Engineers Comments Regarding Surface Water Drainage

Application Reference:	R/239/24/PL	Reviewer Reference:	ADC/SB
Planning Officer:	Harry Chalk	Date of Review:	10/04/2025
Site Name:	Condair Building Artex Avenue Rustington BN16 3LN		
Application Description:	Demolition of existing building (facing Brookside Avenue) and redevelopment of the rear of the site for office use, with ancillary storage facilities and landscaping falling within Class E. This application is in CIL Zone 4 and is zero rated as other development.		
Assessment Number:	1 of 2

Drawing Title
Proposed Drainage Strategy

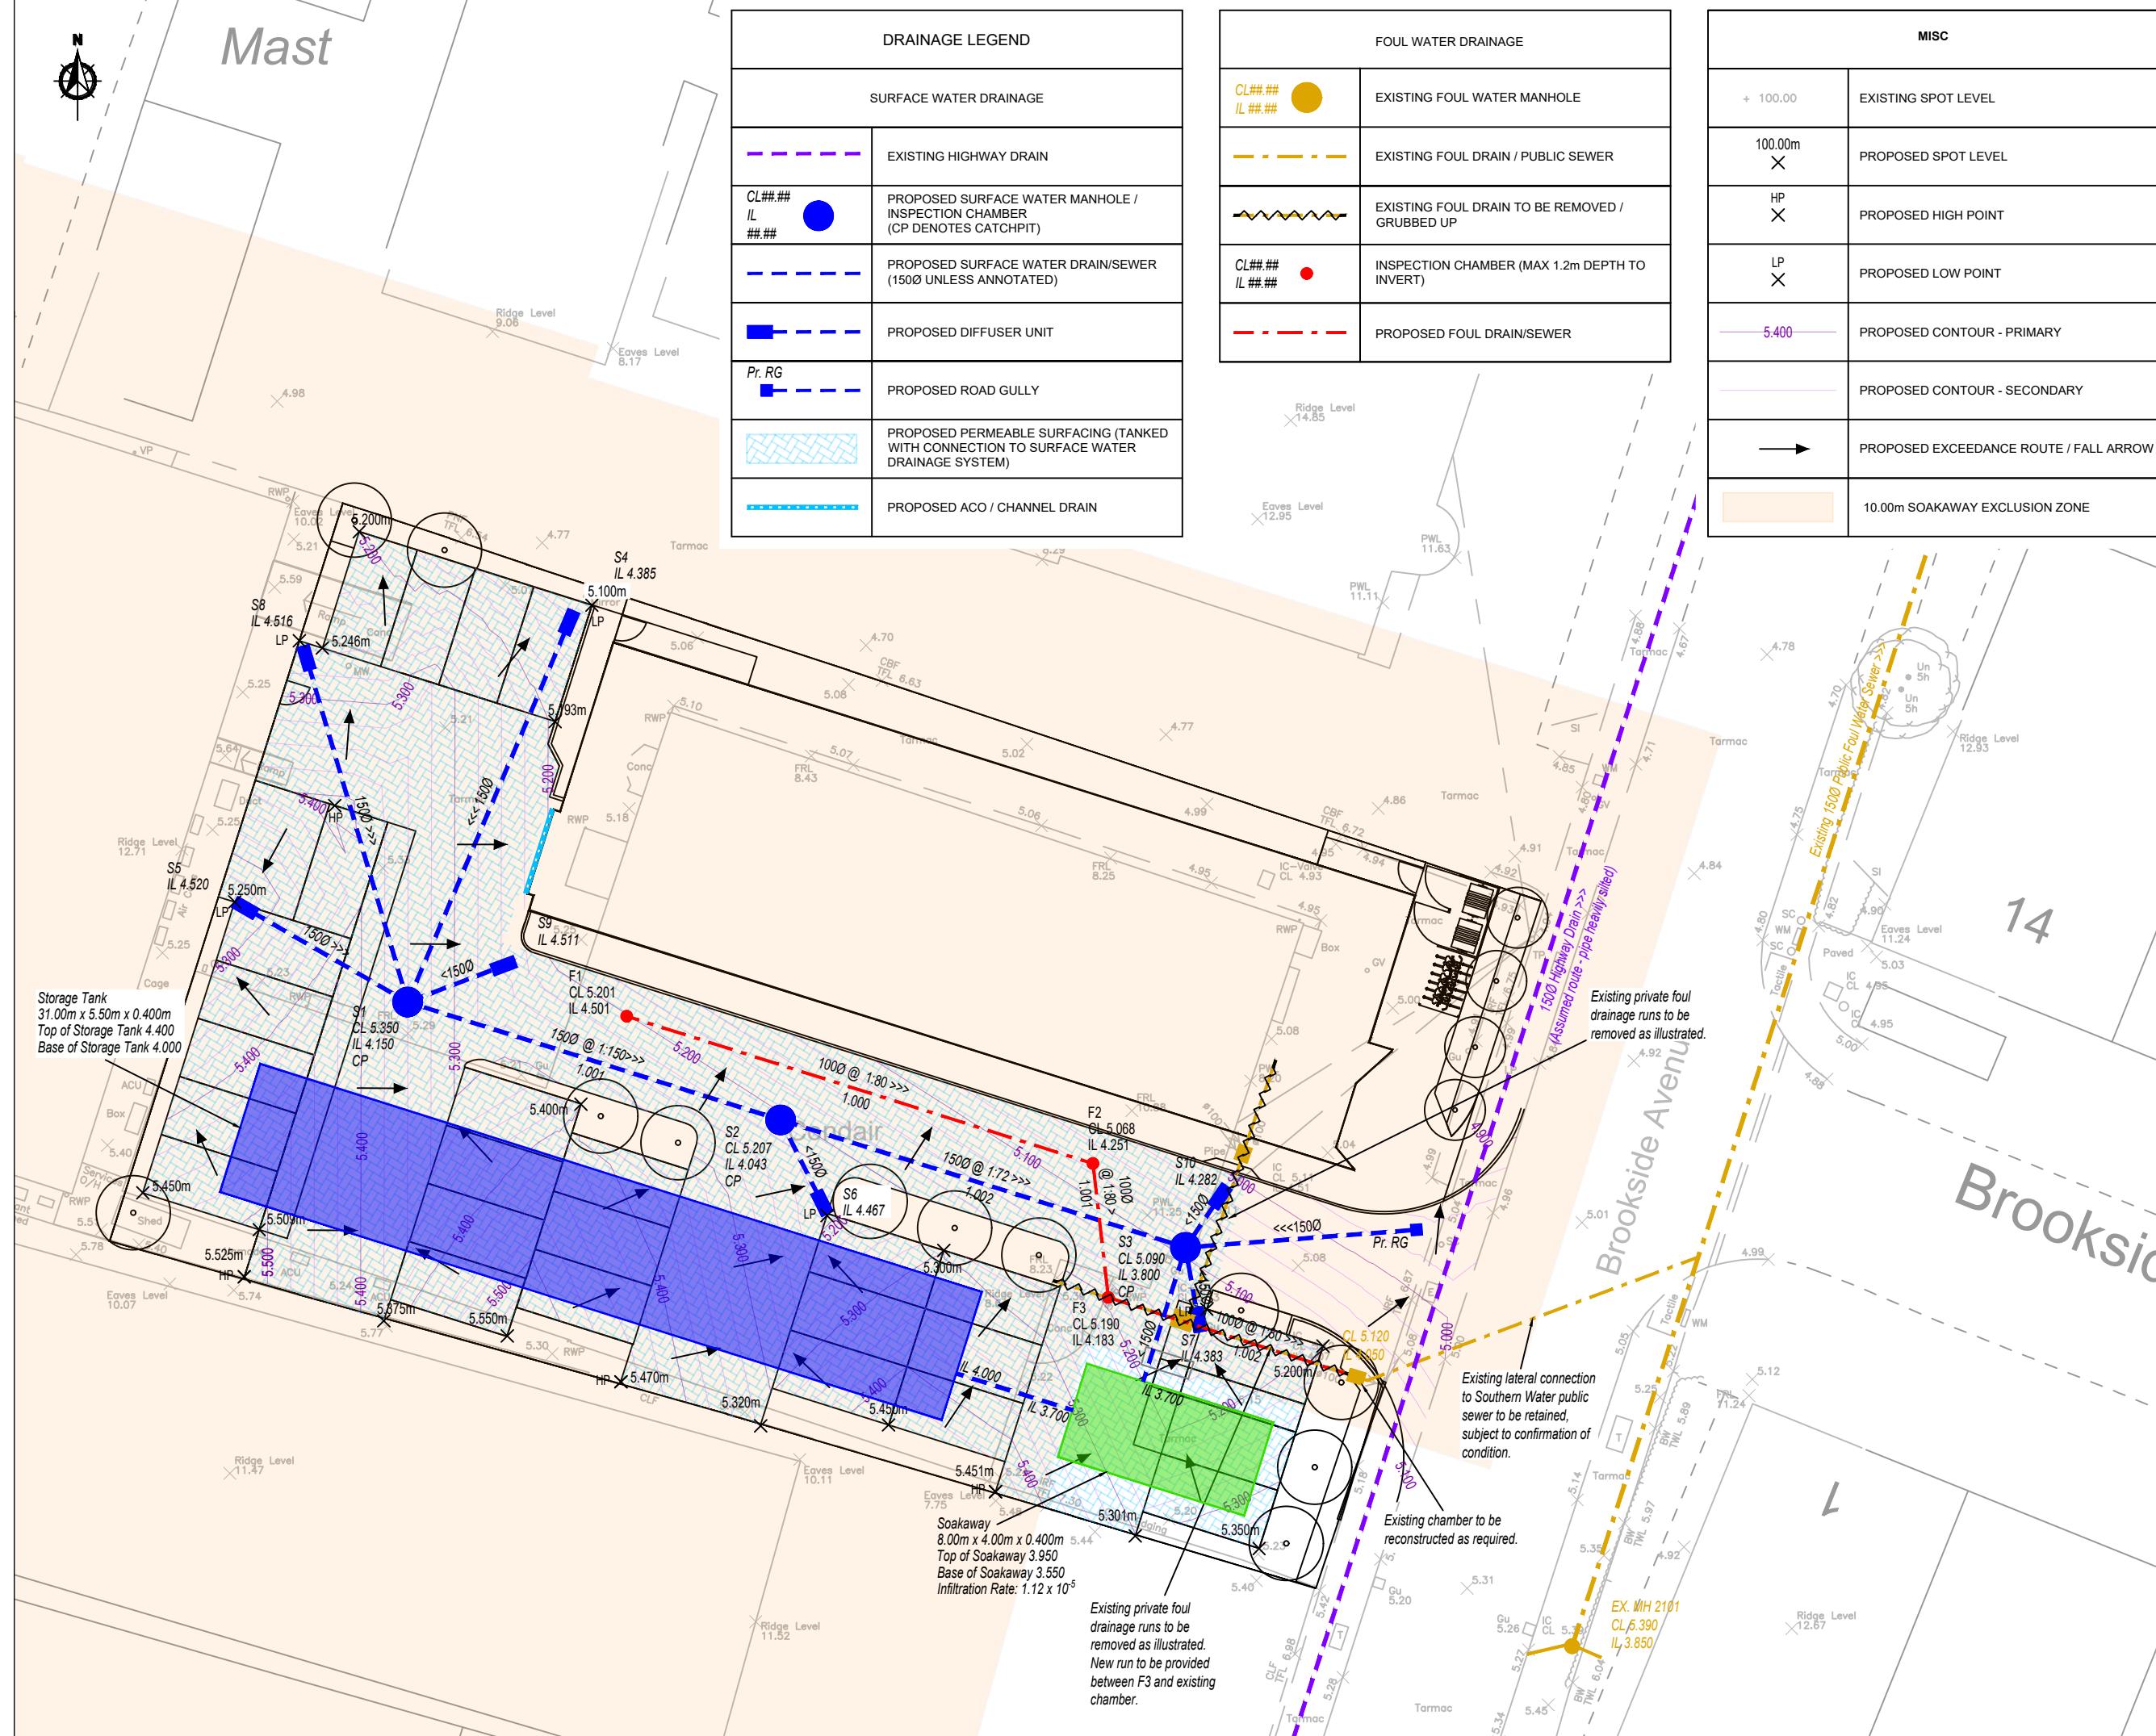
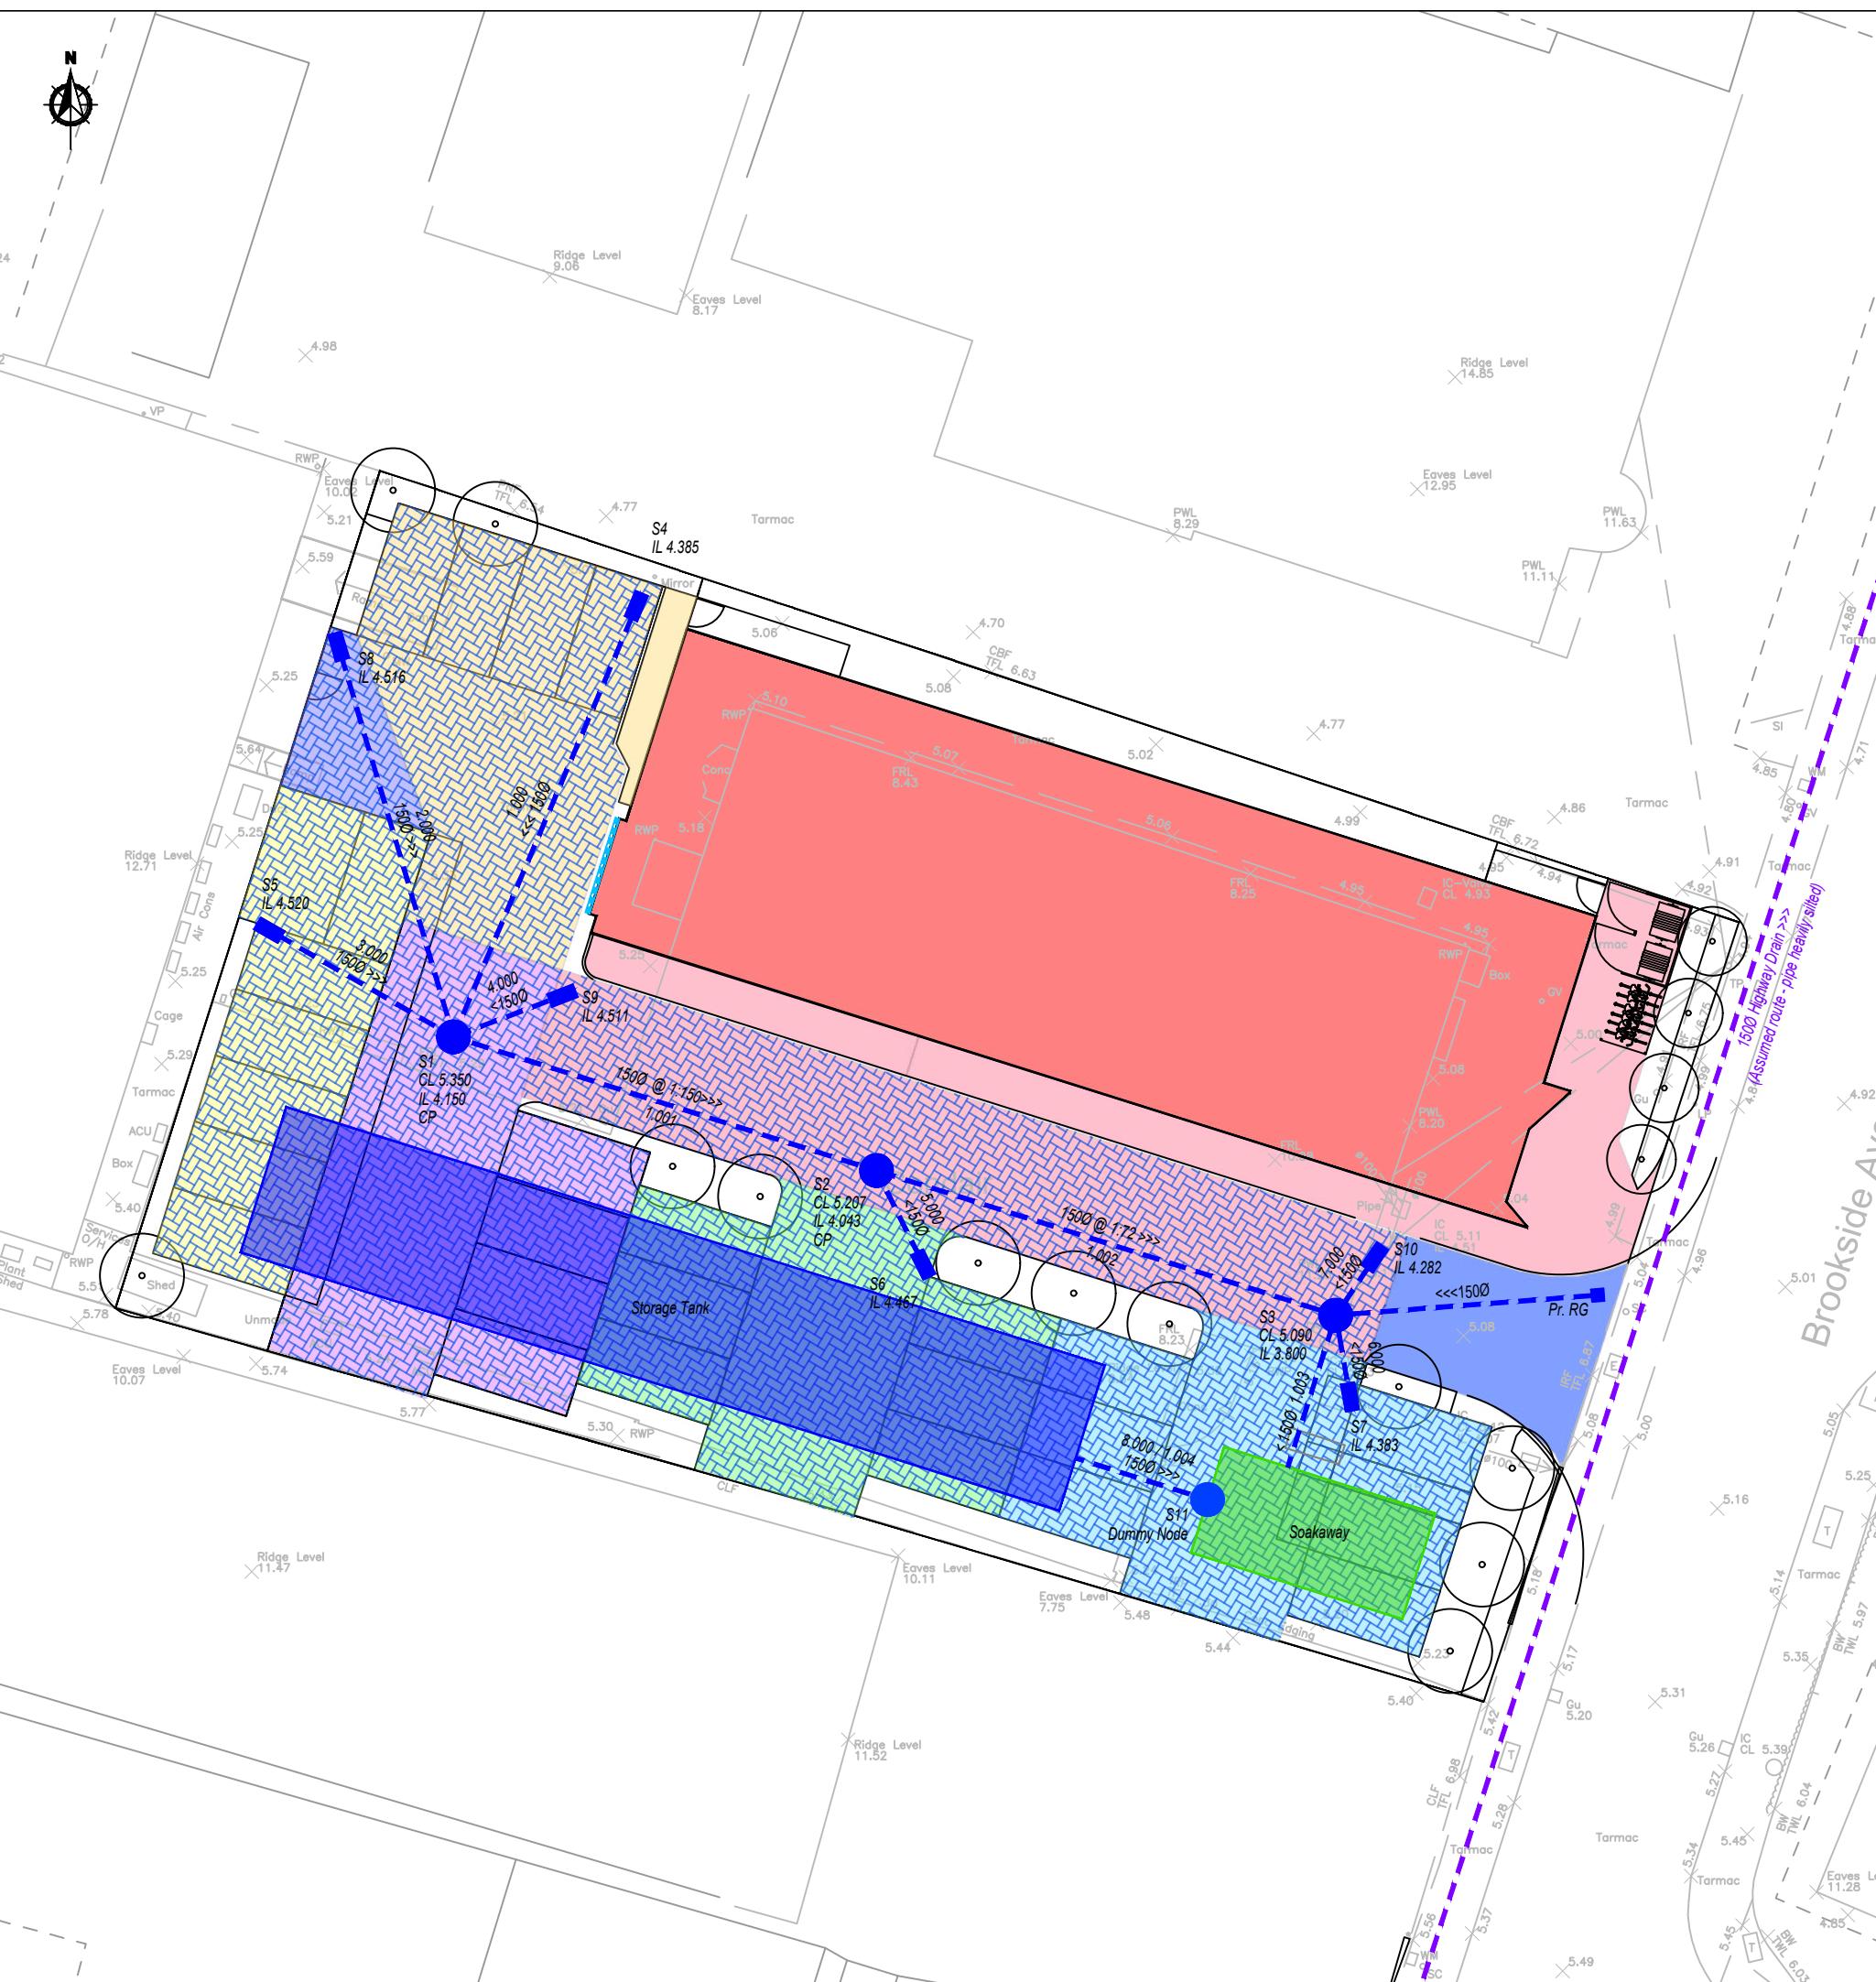
Having discounted infiltration, the designer has proposed to connect surface water to the public highway drainage system. This is because there are no watercourses, surface water or combined sewers in the vicinity of the site. If infiltration is not viable then we are supportive of this strategy. However, the applicant has **no right of connection** of surface water to the highway drainage

network and they have not presented any evidence that they will be able to obtain permission for the connection.

The depth of the highway drainage network is unconfirmed. This should also be evidenced prior to determination to ensure that the site can achieve a gravity connection. Failing to demonstrate that gravity connection is achievable increases the likelihood that an unsustainable pumping solution is proposed.

No formal assessment of how the site is delivering interception has been submitted by the applicant. However, if infiltration is not viable then the applicant will be limited to evapotranspiration and rainwater harvesting to deliver this standard. The proposed permeable paving will meet the objective for its own area, however, for the additional roof area downstream interception components will be required. Rainwater harvesting systems must be designed for supply purposes and using evapotranspiration will require a significant vegetated surface. This may affect the proposed scale and layout of the development.

There is a small area at the south of the site which is at risk of surface water flooding. The designer may need to account for surface water entering the system from the neighbouring site in their surface water drainage design. This is inadequately demonstrated by the submission.

Permission in principle to connect surface water to the public highway drainage network on Brookside Avenue. This should include recognition and commitment to any remediation works that are necessary. (Surveys may be required).

3. Evidence that interception drainage is provided for all positively drained areas.
4. Evidence how surface water flood risk has been considered for the purposes of the surface water drainage design.
5. Demonstrate that the proposed discharge rates and volumes have been determined using a methodology prescribed by The SuDS Manual. Justify any deviance from greenfield runoff rates and volumes.
